# Rezoning Transportation Analysis

Petition Number: 2023-034

Date	Description
06-28-23	First Review (TM)
07-28-23	Second Review (TM)
08-21-23	Trip Gen. Update (TP)
10-26-23	Third Review (TM)

RZ 1.0

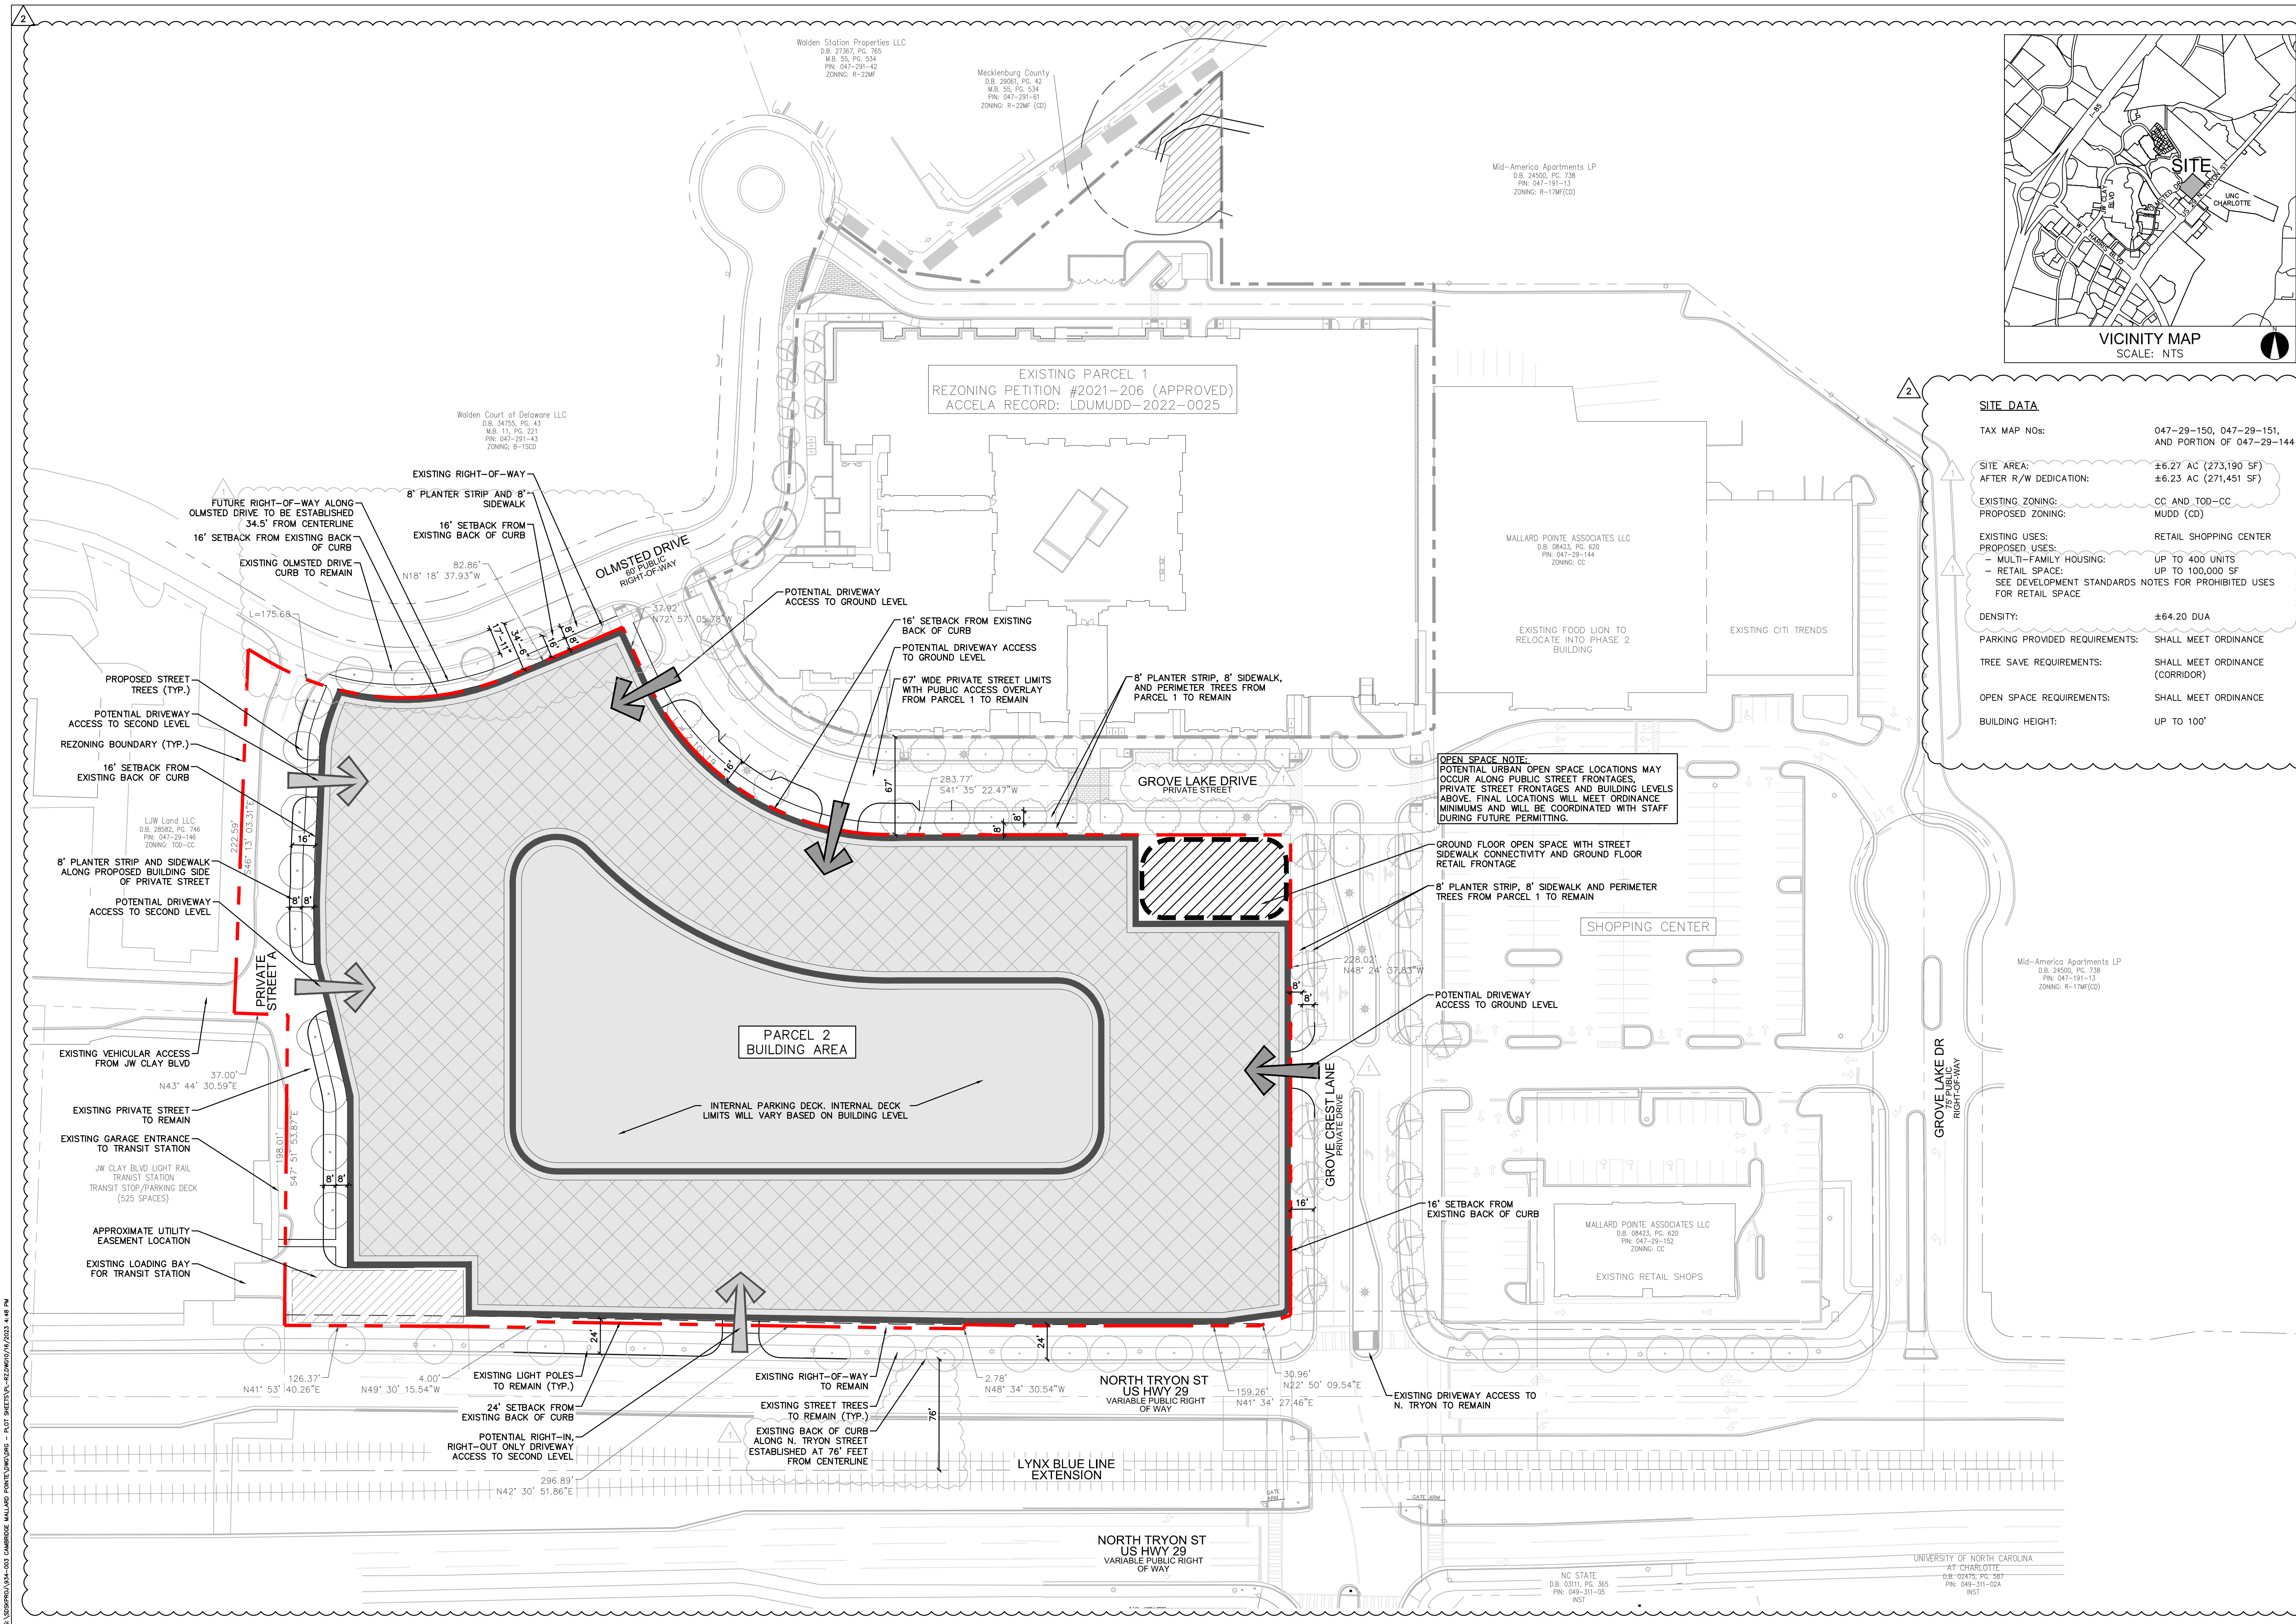
Label and dimension the curb and gutter from the centerline for each road on the site plan.

3. **NEW COMMENT FROM 10-26-23:** Remove Access point that was added to Tryon Street.

8. Request: Revise site plan and conditional note(s) to commit to extending the 8-foot sidewalk on Olmsted Drive to J W Clay Boulevard CIP project.
9. ~~Add a conditional note specifying "the Petitioner shall dedicate and convey in fee simple all rights-of-way to the City before the site's first building certificate of occupancy is issued. CDOT requests rights-of-way set at 2' behind back of sidewalk where feasible."~~
